Oaklands Farm Solar Park

Consultation Report

Appendix 13.1 - Section 42 Copies of Responses and Summary of
Feedback and Regard Had

Document Reference: EN010122/APP/5.2

Indicative Abnormal Load Swept Path Analysis

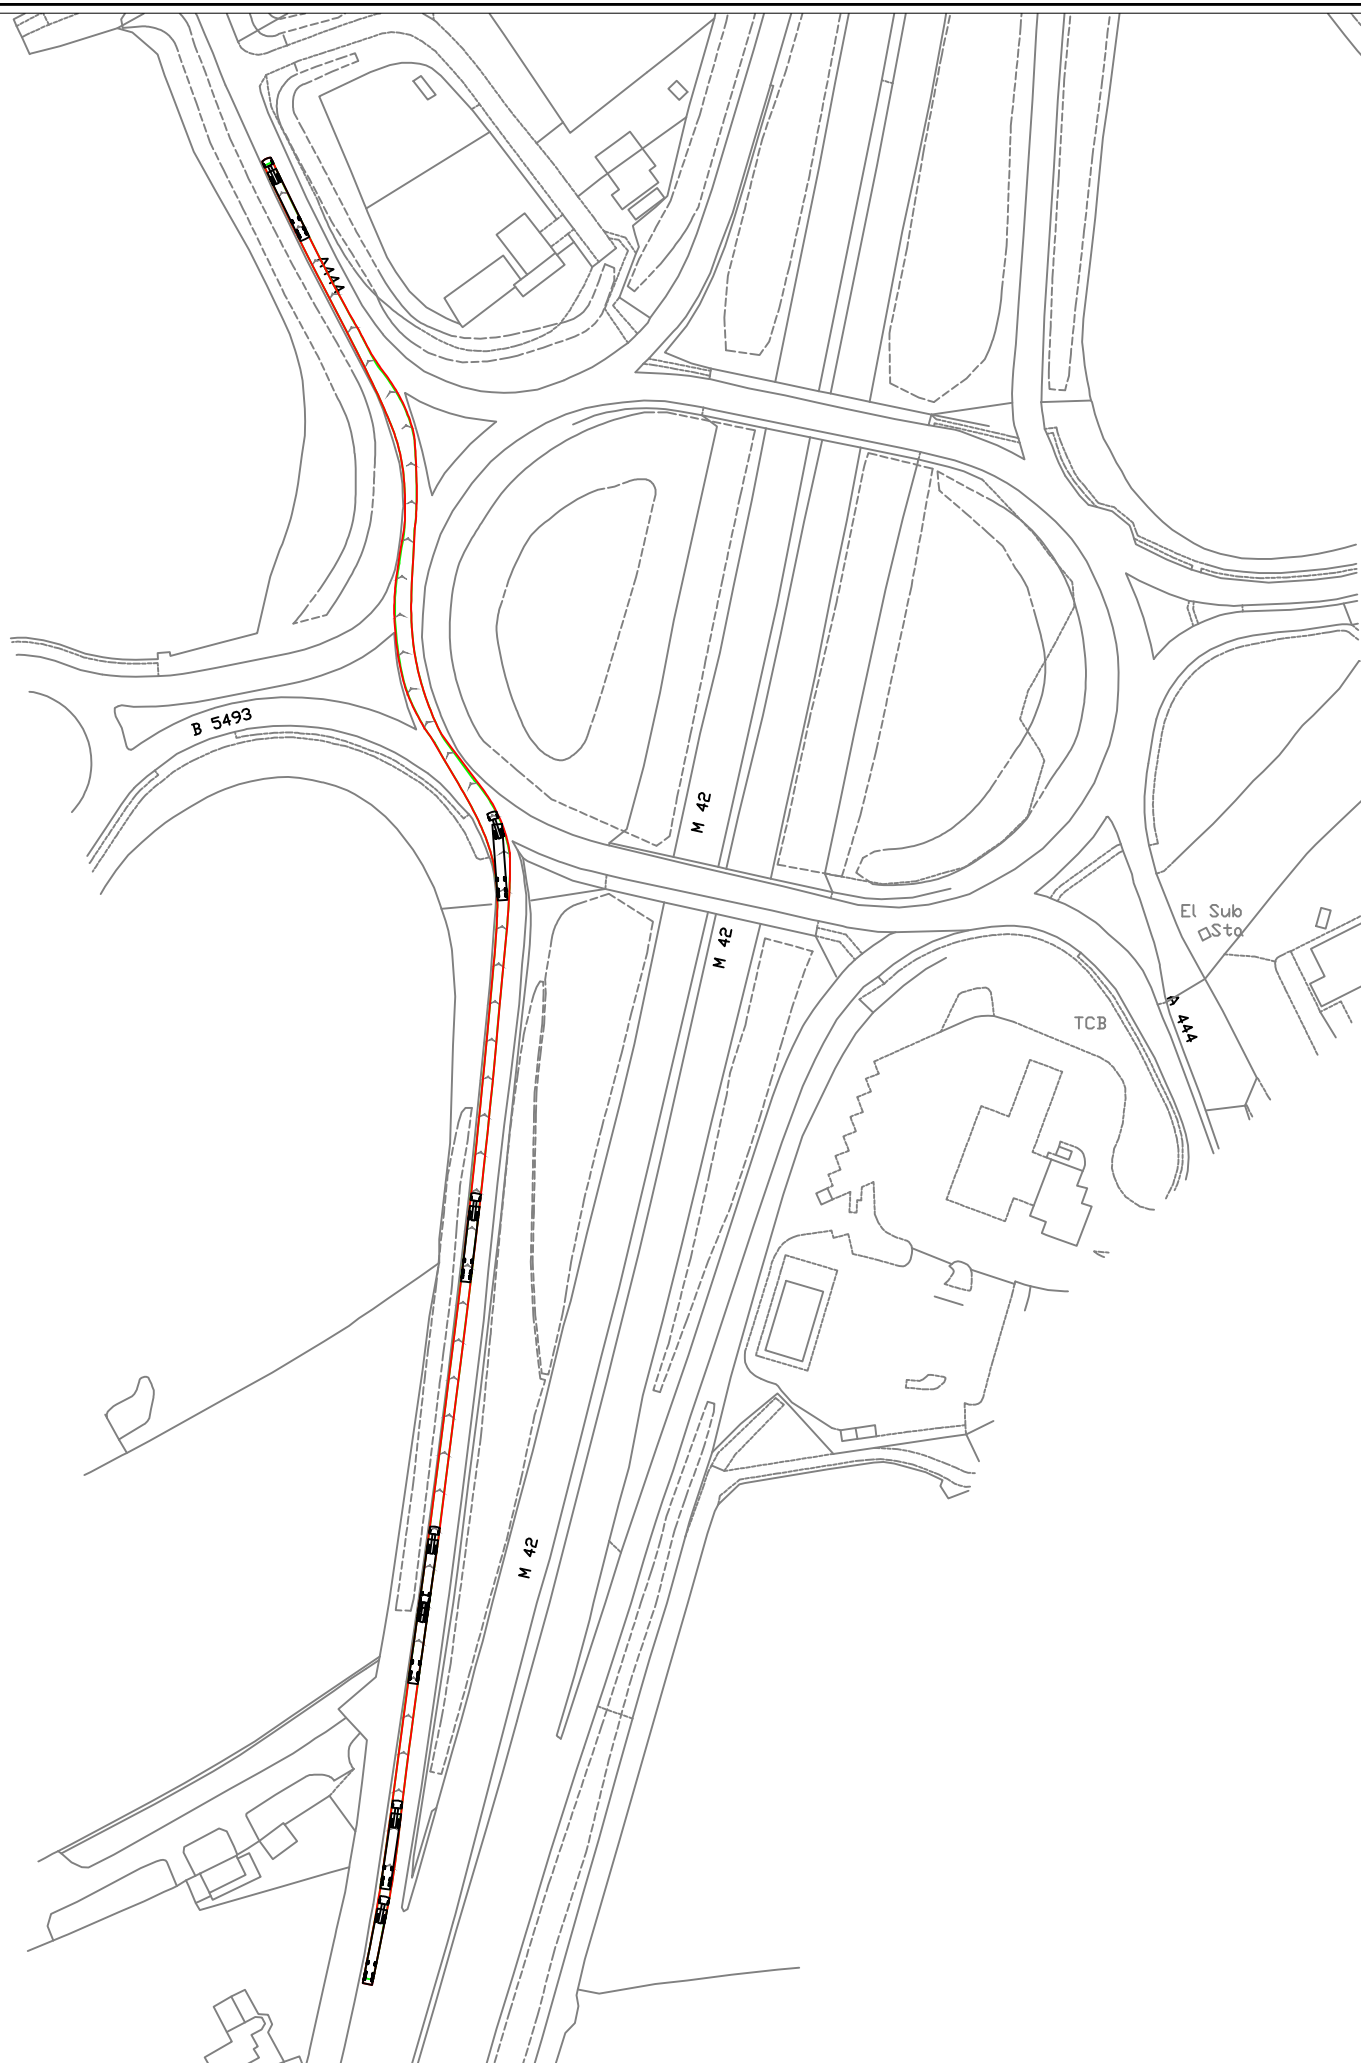
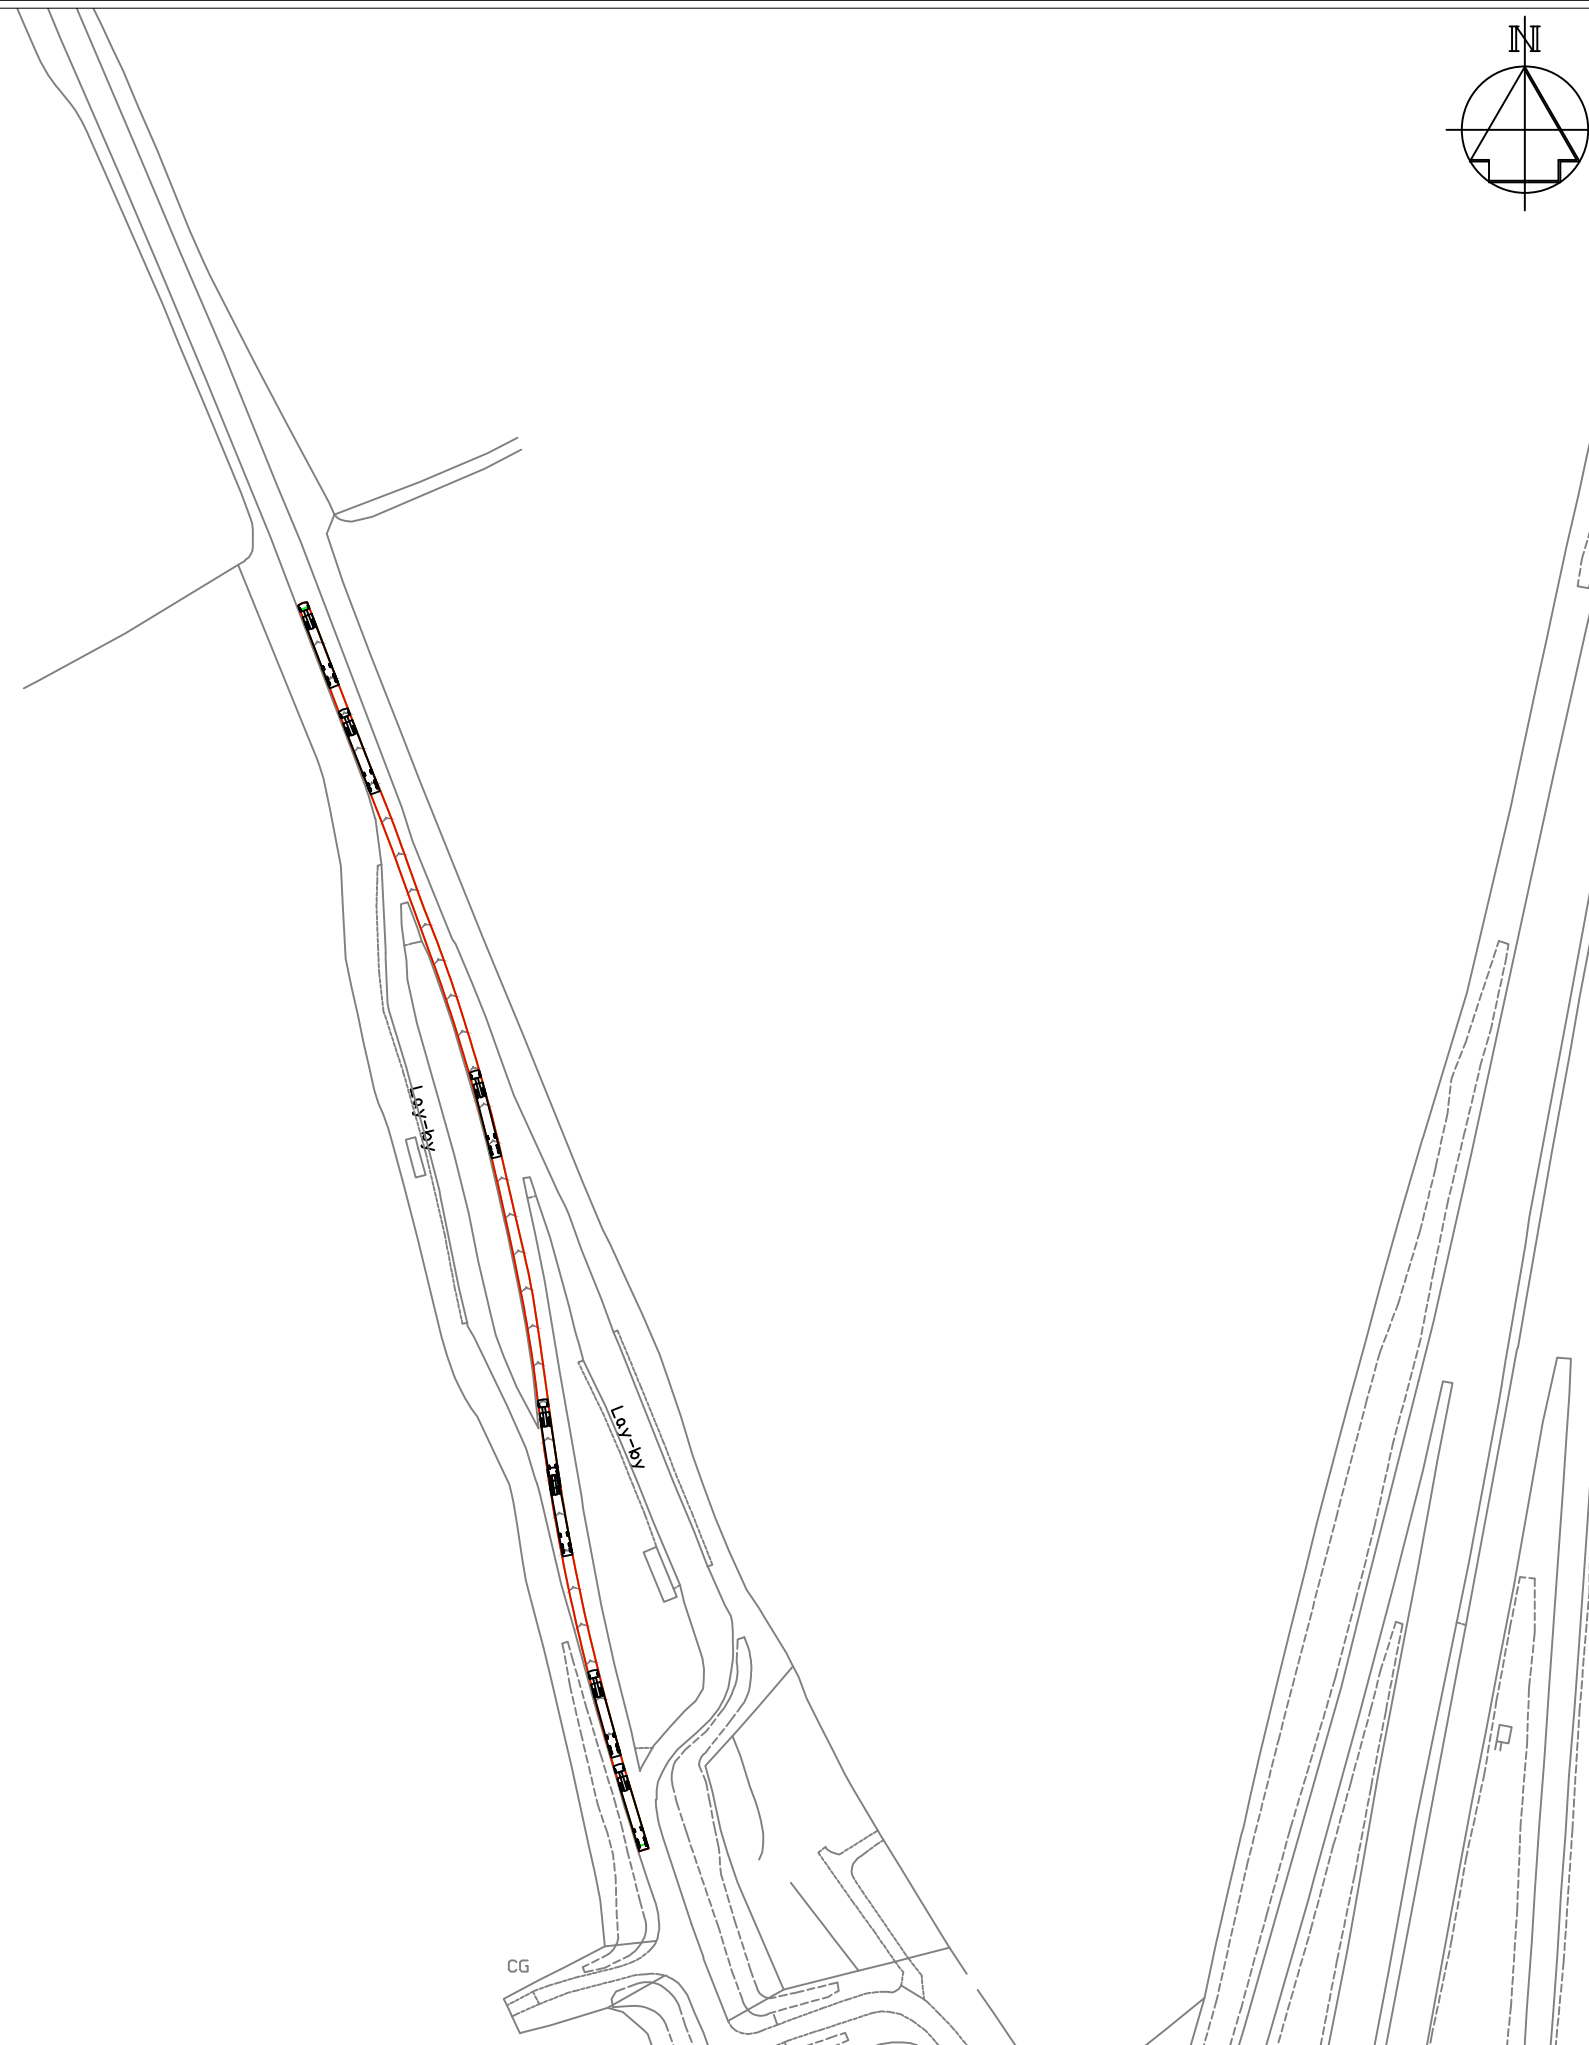
- Request for further information including swept path analysis of access points to the site to assess suitability or any highway safety concerns.
- The CEMP should clarify whether any safety issues should be considered during operation, although it is noted that vehicle movements at this point will be minimal.
